Approval of details reserved by condition imposed under ref FG/105/20/PL relating to Condition Nos 3 - car parking, 4 - materials & finishes, 5 - covered & secure cycle parking spaces, 6 - Arboricultural Impact Assessment, 8 - decentralised, renewable & low carbon energy and 9 - charging of electric vehicles

Tudor Close Public House Ferringham Lane Ferring BN12 5NQ

Arun District Council have decided to **REFUSE details reserved by condition for the following reasons:**

R.1 - Parking & Charging Arrangement

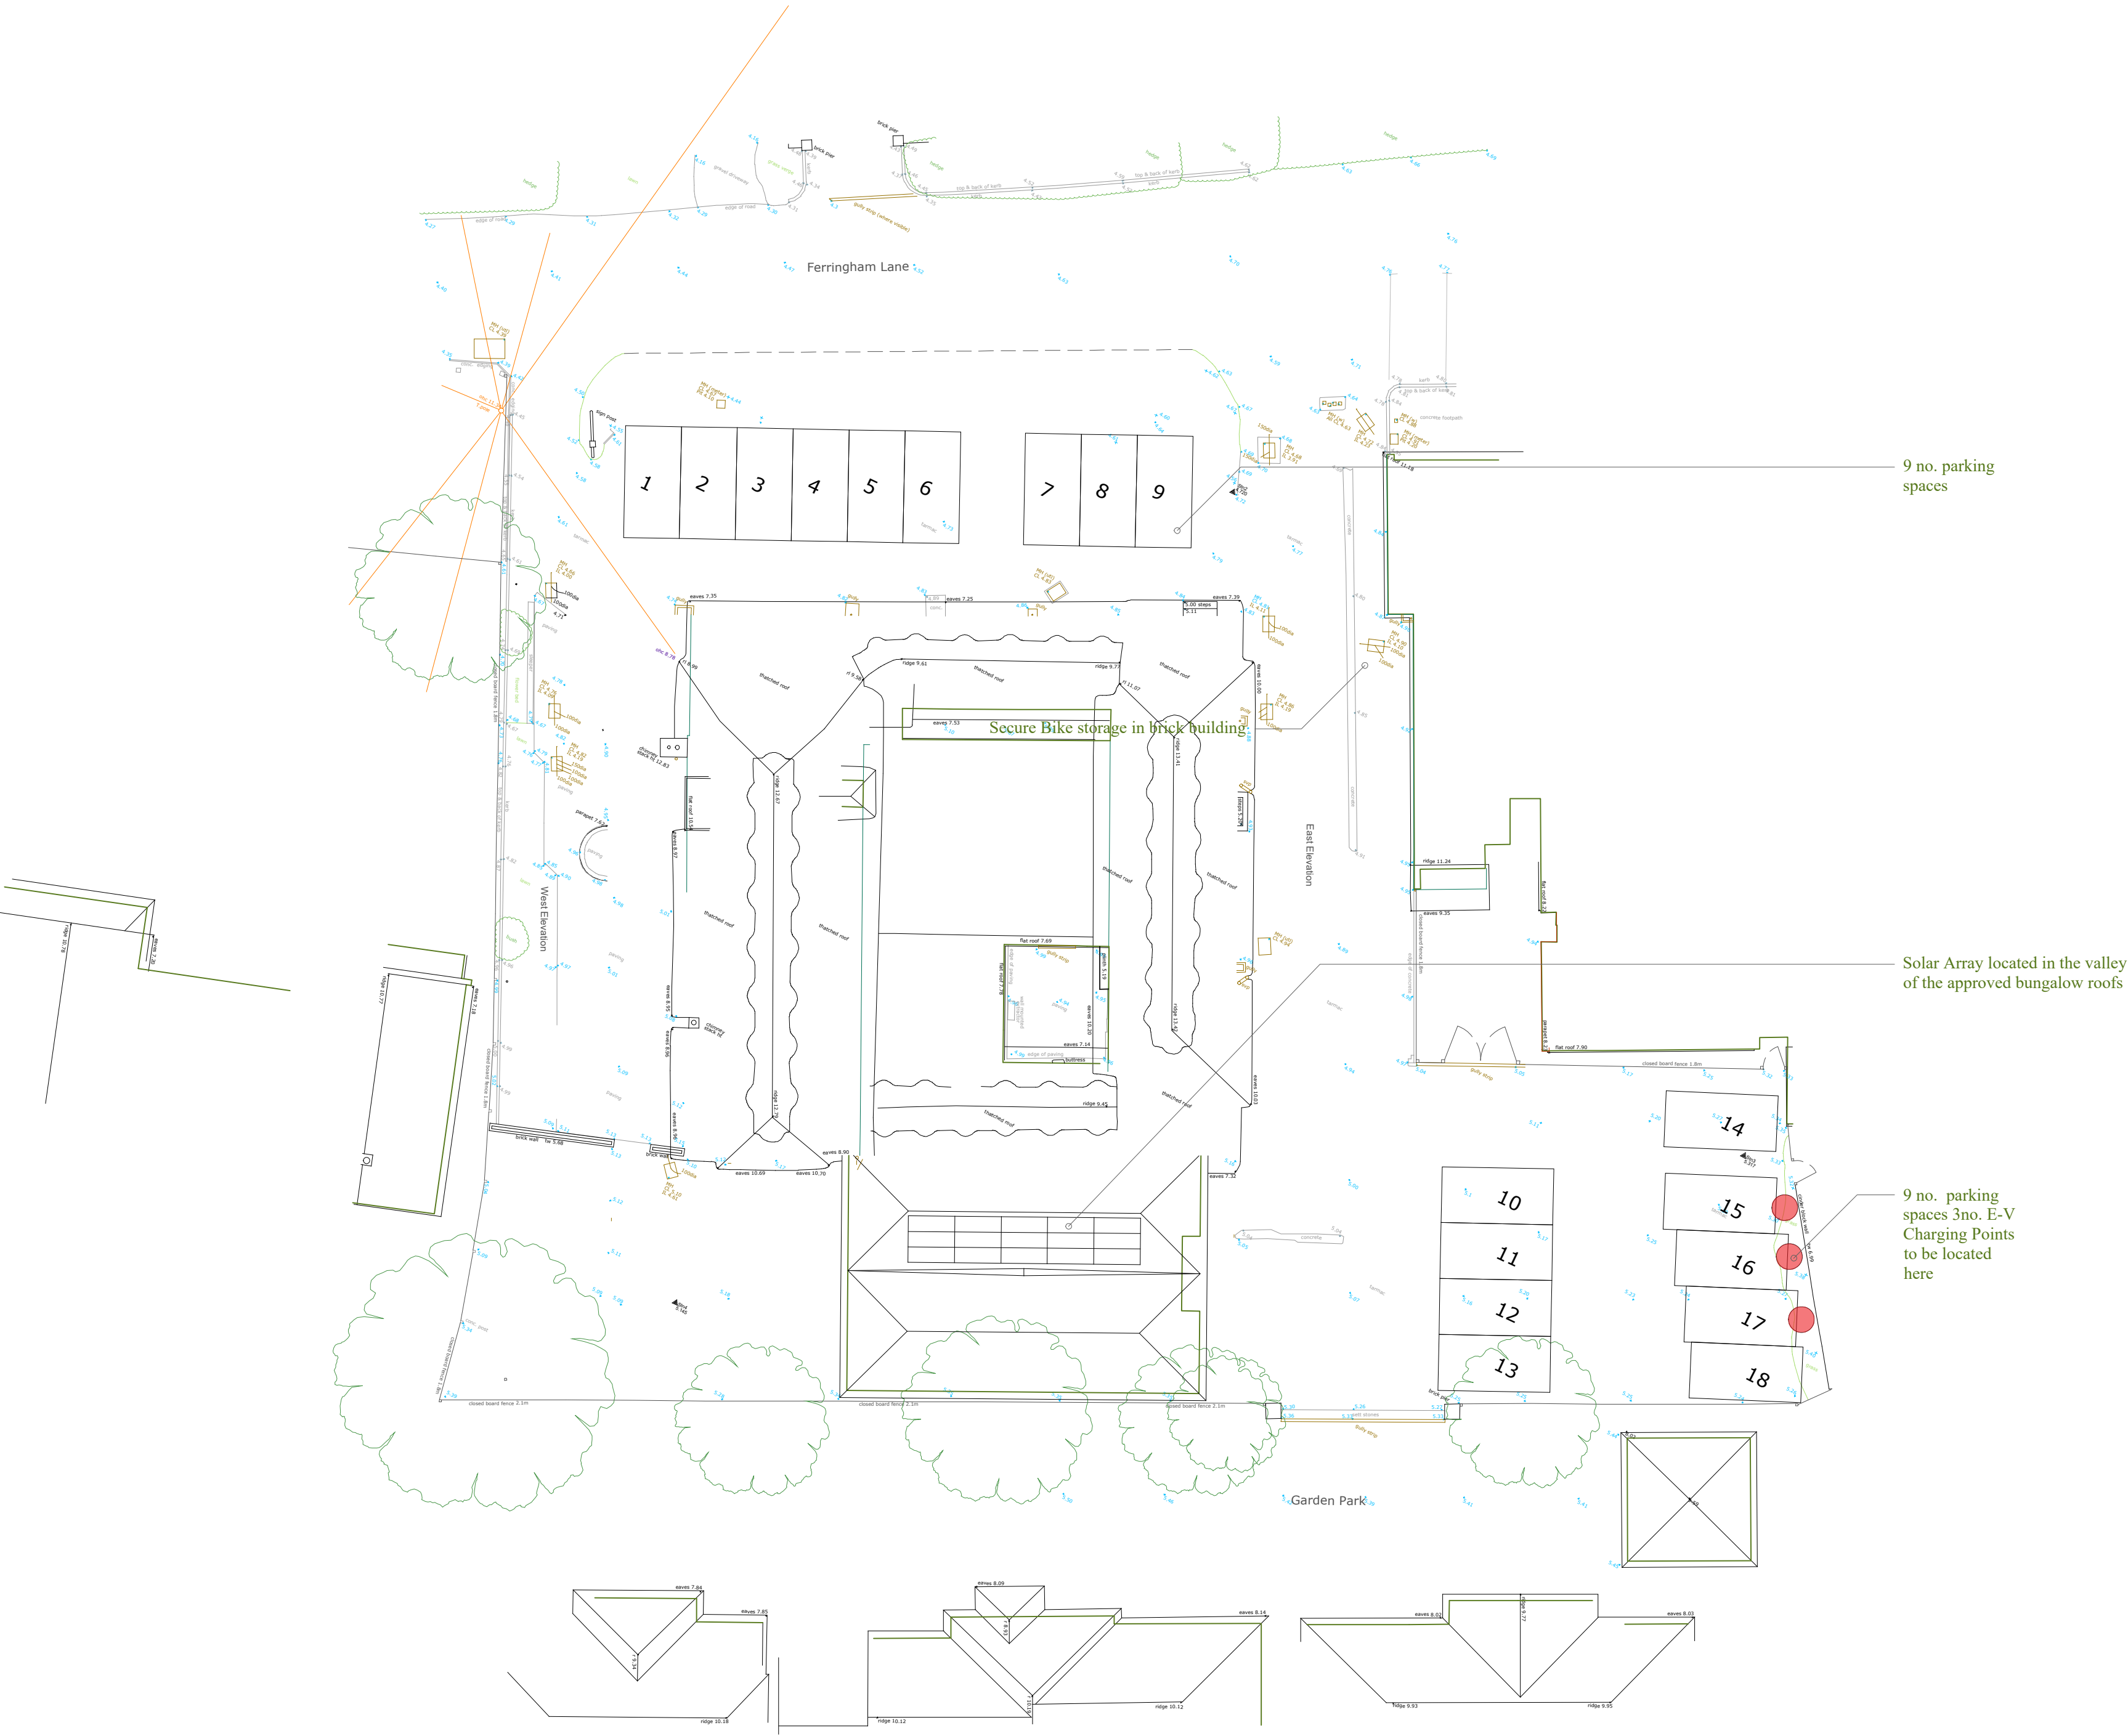
According to the requirement of ADC Parking Standards (SPD), Principle 3, 2.16 Active charging points for electric vehicles shall be provided at a minimum of 20% (at 2019 levels of provision) of all parking spaces with ducting provided at all remaining spaces where appropriate to provide passive provision for these spaces to be upgraded in future.

The applicant has proposed to install 3 EVCs and proposes 7 flats and 2 new residential dwelling units providing 18 parking spaces. From the above it is clear that 4 active (14 passive) charging points for

electric vehicles should be provided.

For the above reason the condition 9 cannot be discharged and you will need to make a revised submission.
